CITY OF ALBUQUERQUE

October 30, 2020

**Re: Dr. Fanning Orthodontics
8130 Ventura St. NE
30-Day Temporary Certificate of Occupancy
Transportation Development Final Inspection
Engineer's/Architect's Stamp dated 7-31-19 (C20D084)
Certification dated 10-28-20**

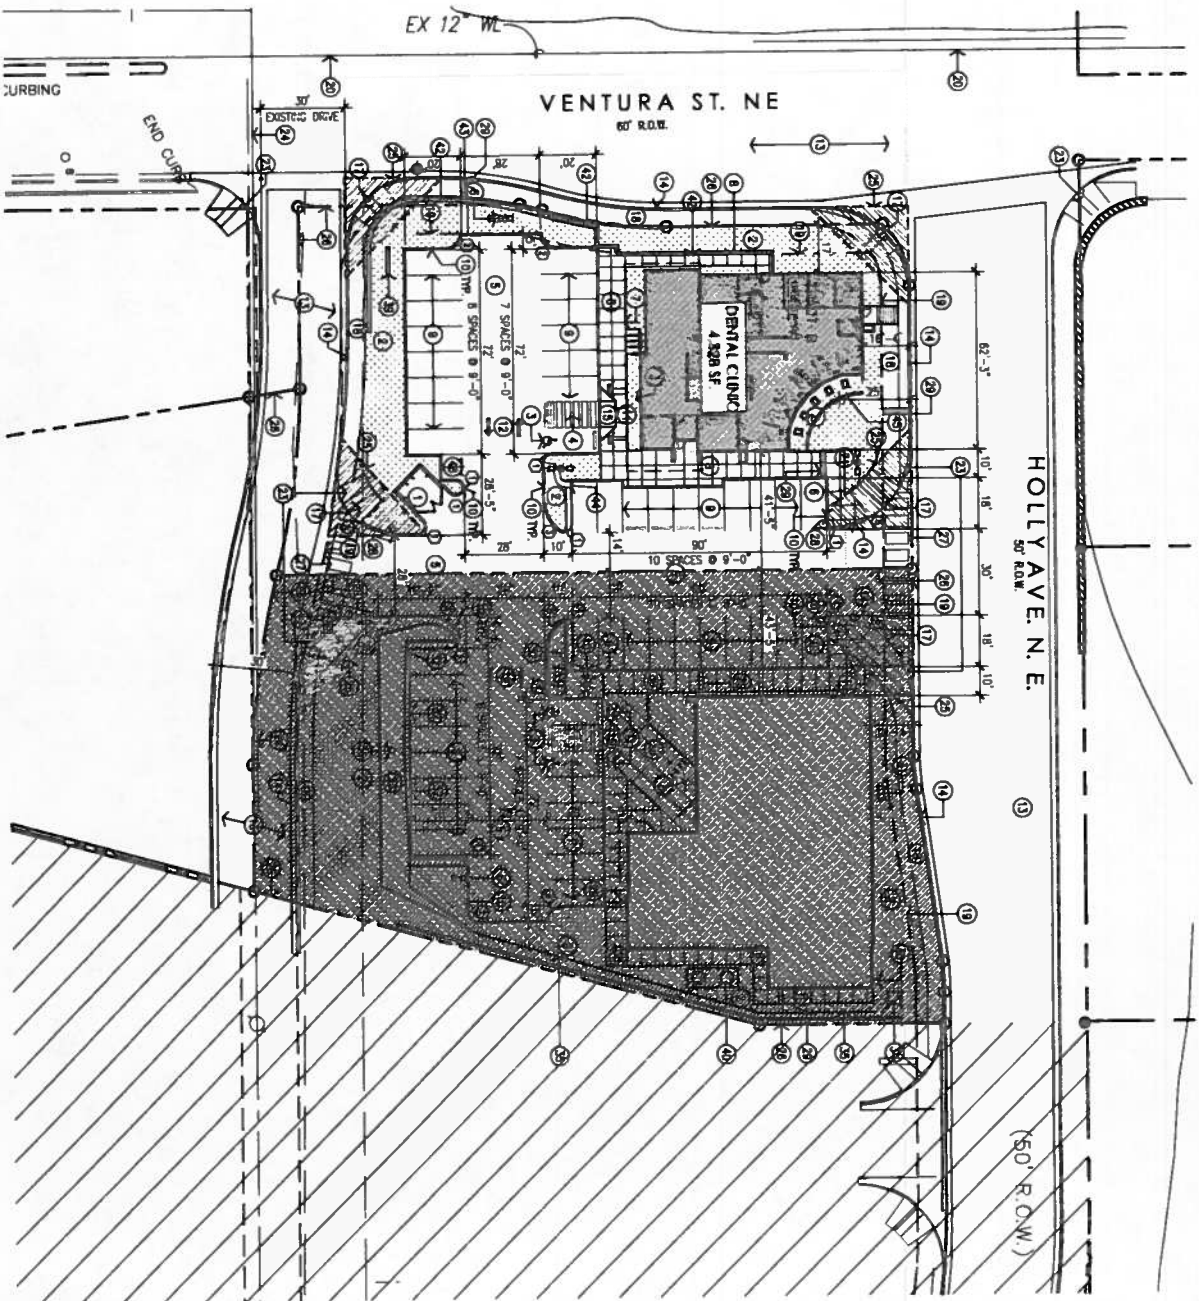
- Please add MC sign. Motorcycle parking spaces shall be designated by its own conspicuously posted upright sign, either free-standing or wall mounted per the IDO.
- Please remove construction debris and equipment.
